Our Ref: LU/386/17/PL
Your Ref:

Town & Country Planning Act 1990 (as amended)
Town and Country Planning (Development Management Procedure) (England) Order 2015
Application for Planning Permission

Development Change of use of land for the stationing of 14 No. mobile homes for permanent residential occupation. This application is a Departure from the Development Plan.
Location Land to East of Torri House Old Mead Road Littlehampton

Site Plan	
Date	November 2017
Scale	1 : 500 @ A3
Sheet	MJS/11-2017/ PL47-02

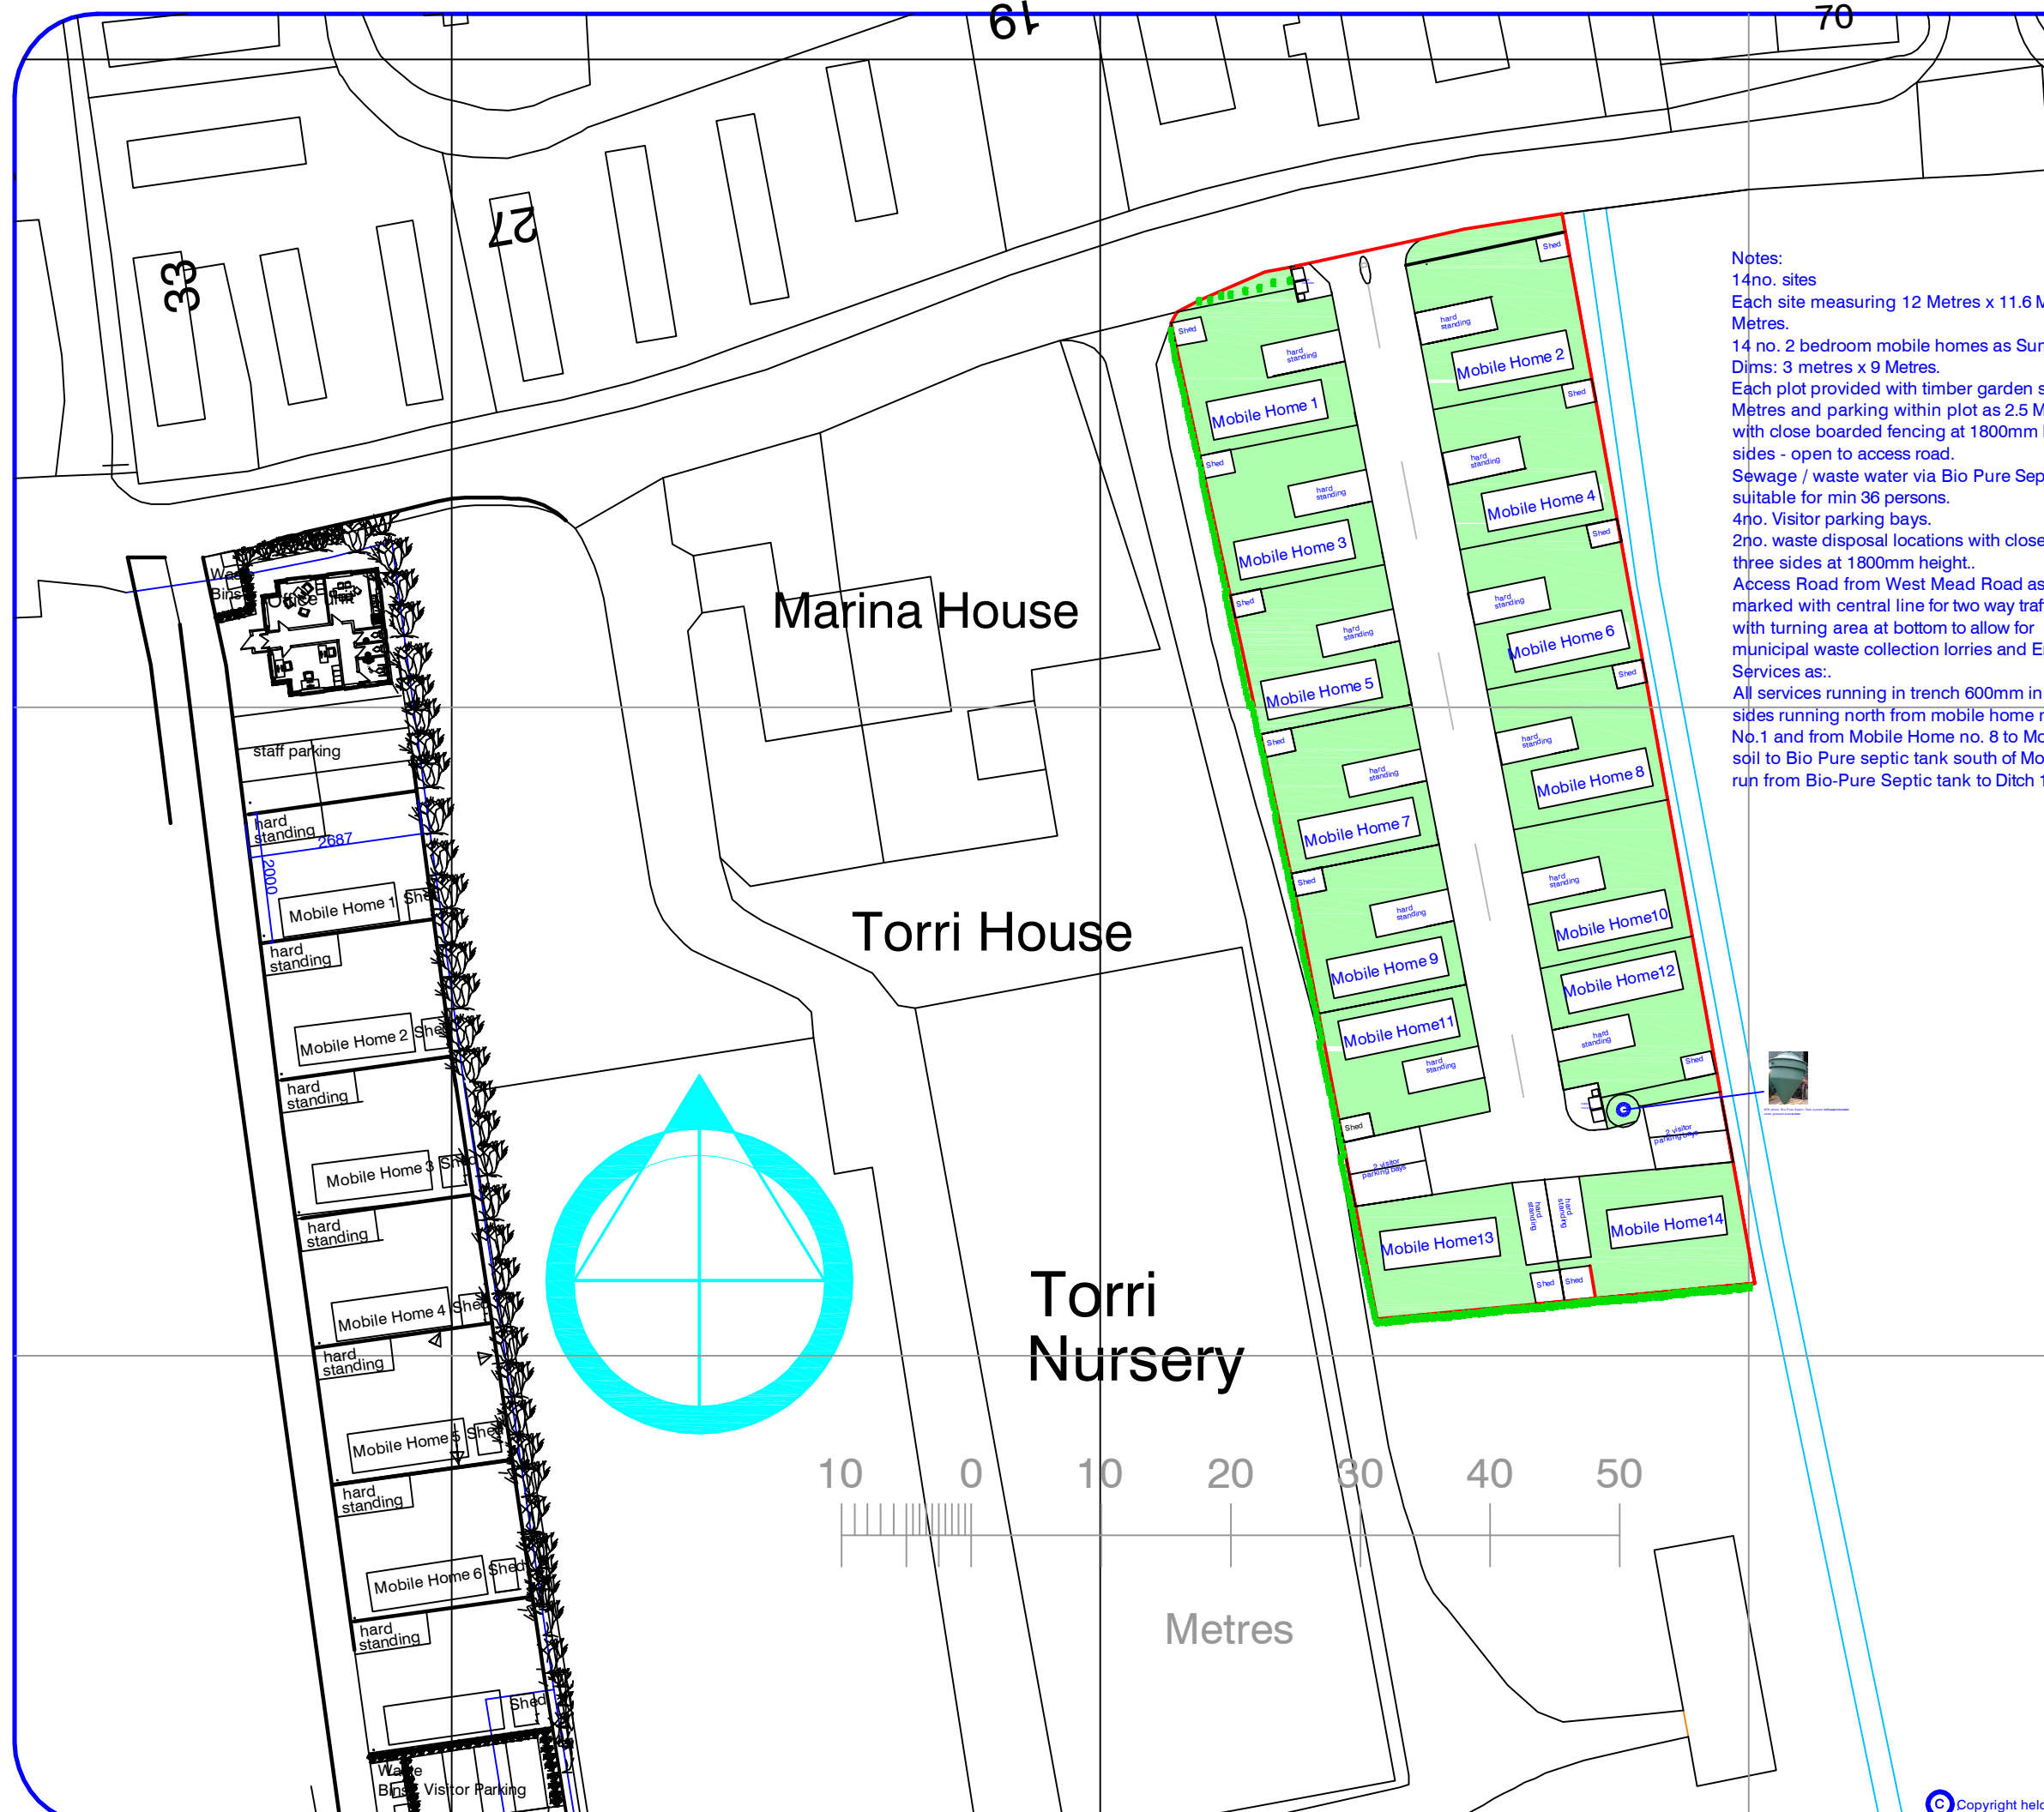
Please provide floor plans and elevations for the proposed shed.

Location Plan		Sheet
Date	November 2017	MJS/11-2017/ PL47-01A
Scale	1 : 2500 @ A3

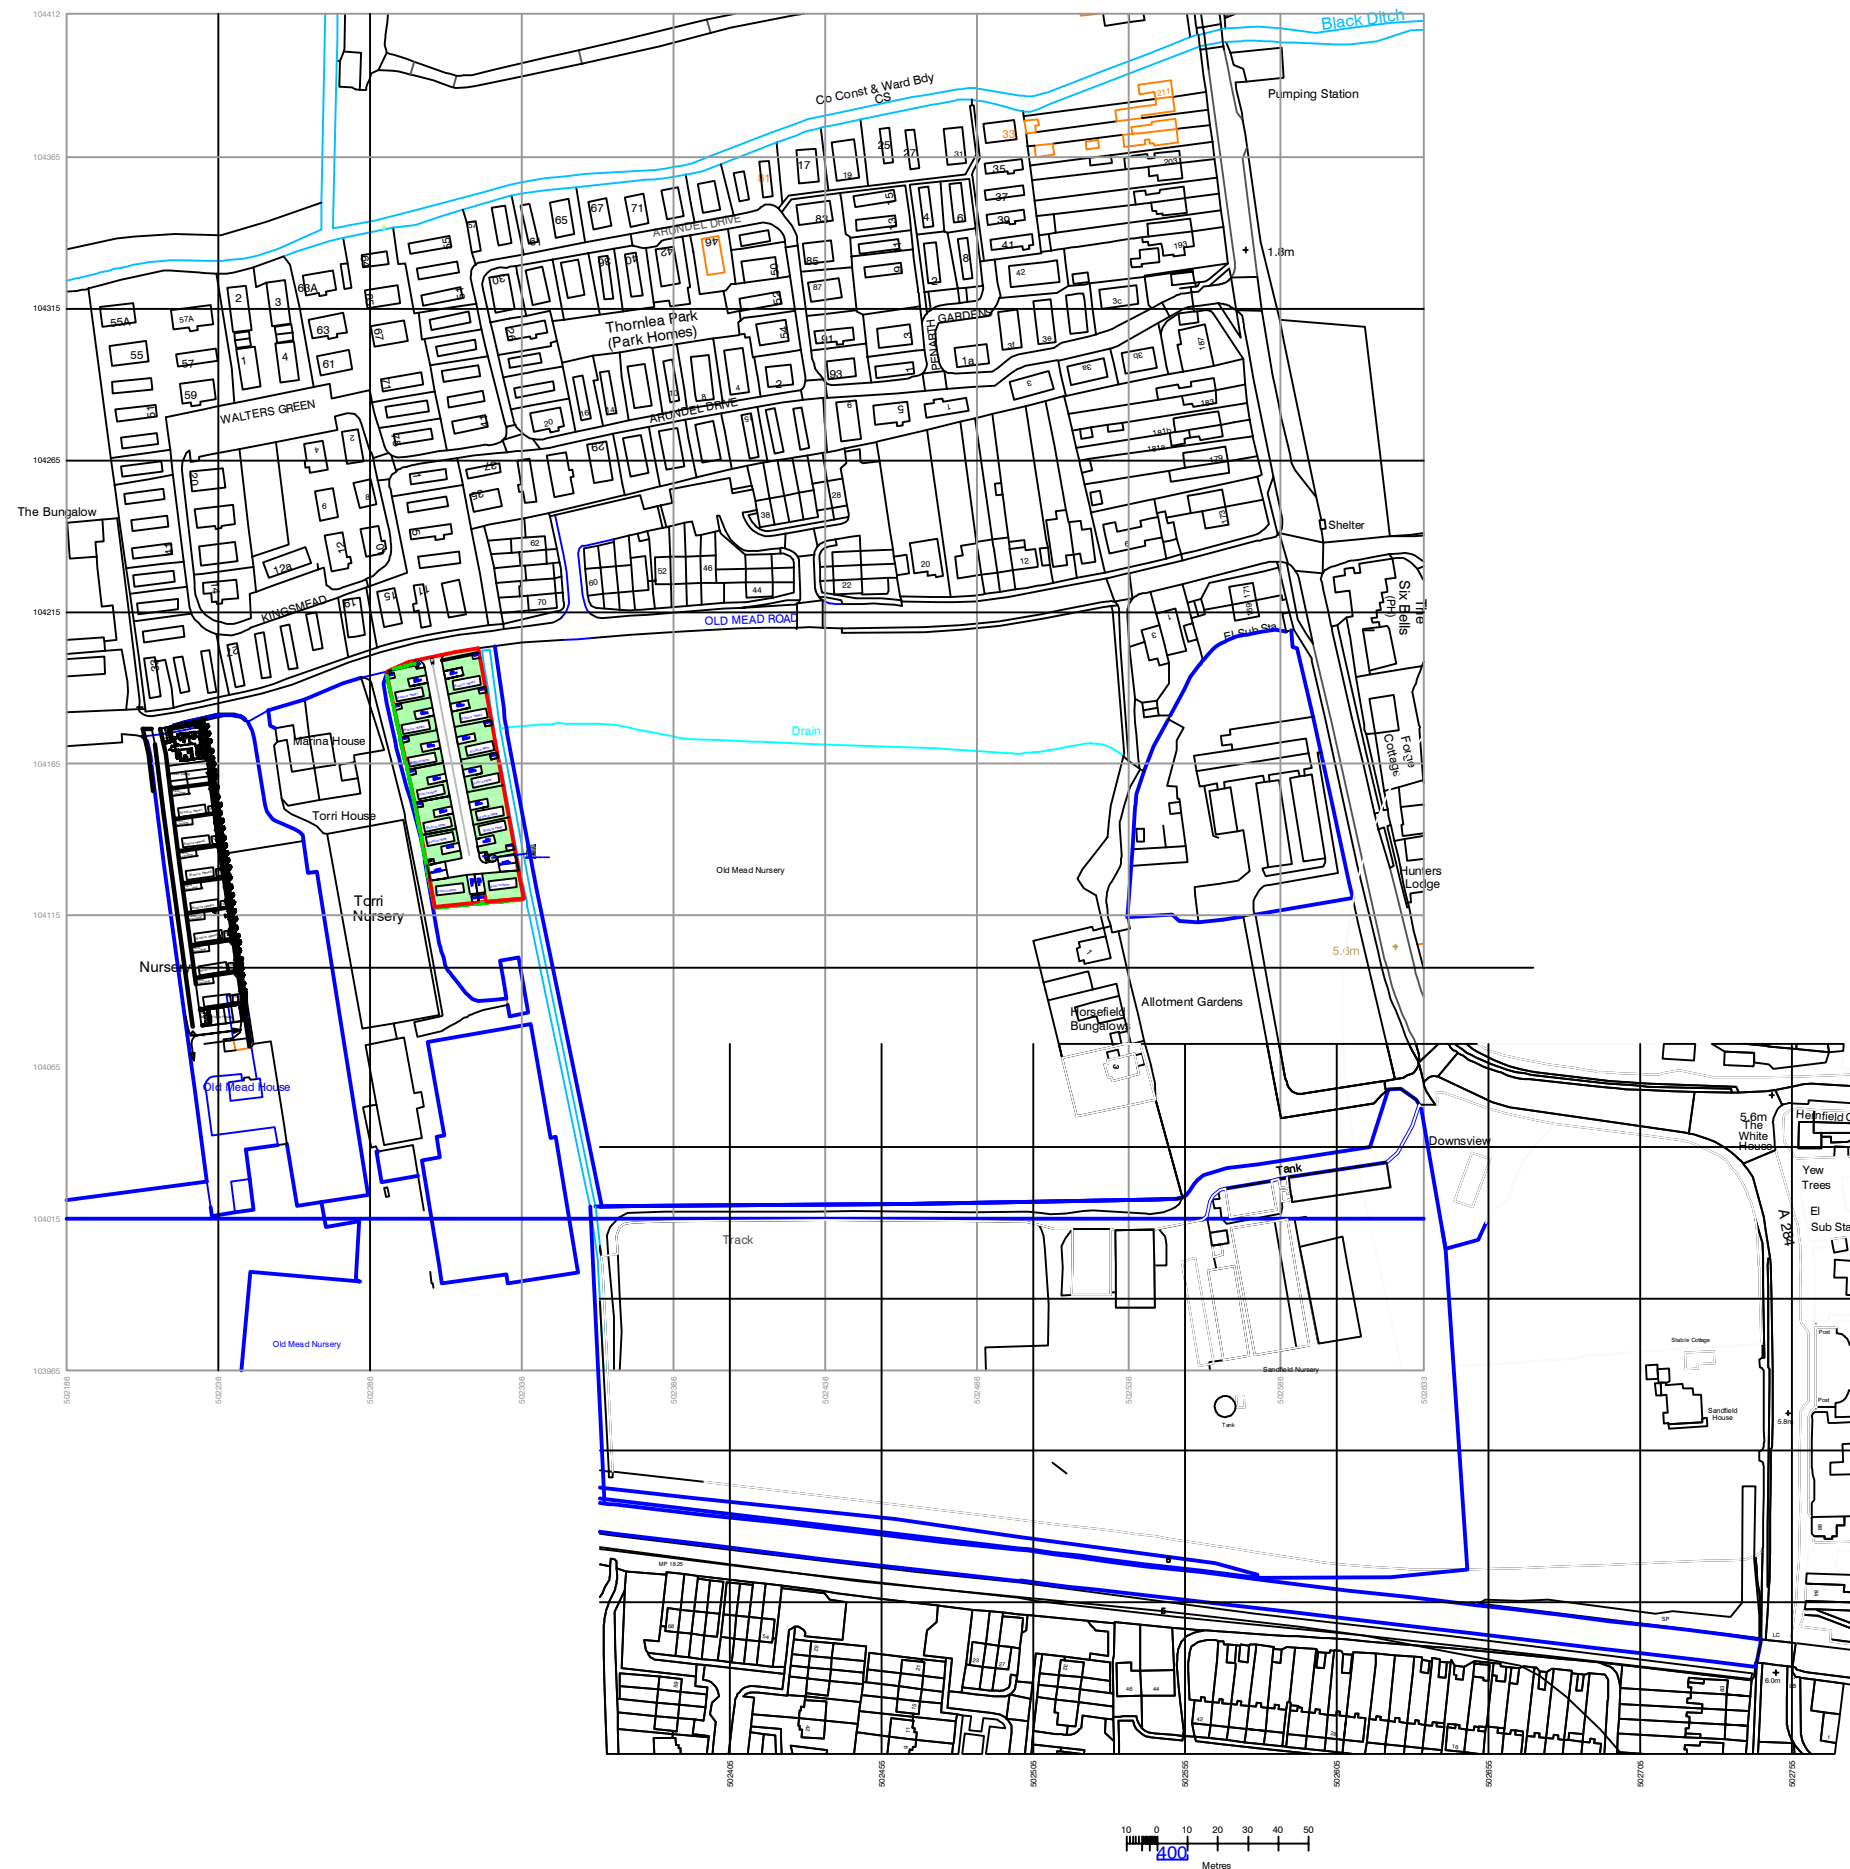
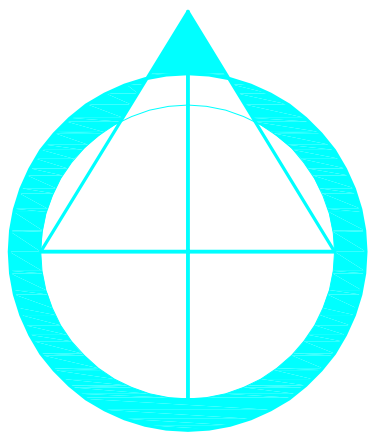
Location Plan Amend

Please submit 1 electronic or 3 paper copies of a location plan at a scale of 1:1250 or 1:2500 for rural areas. Further details of what must be included on the plan can be found in the National Validation Requirements. Please only red edge the application site and blue edge any other land adjoining the application site owned/in control of the applicant.
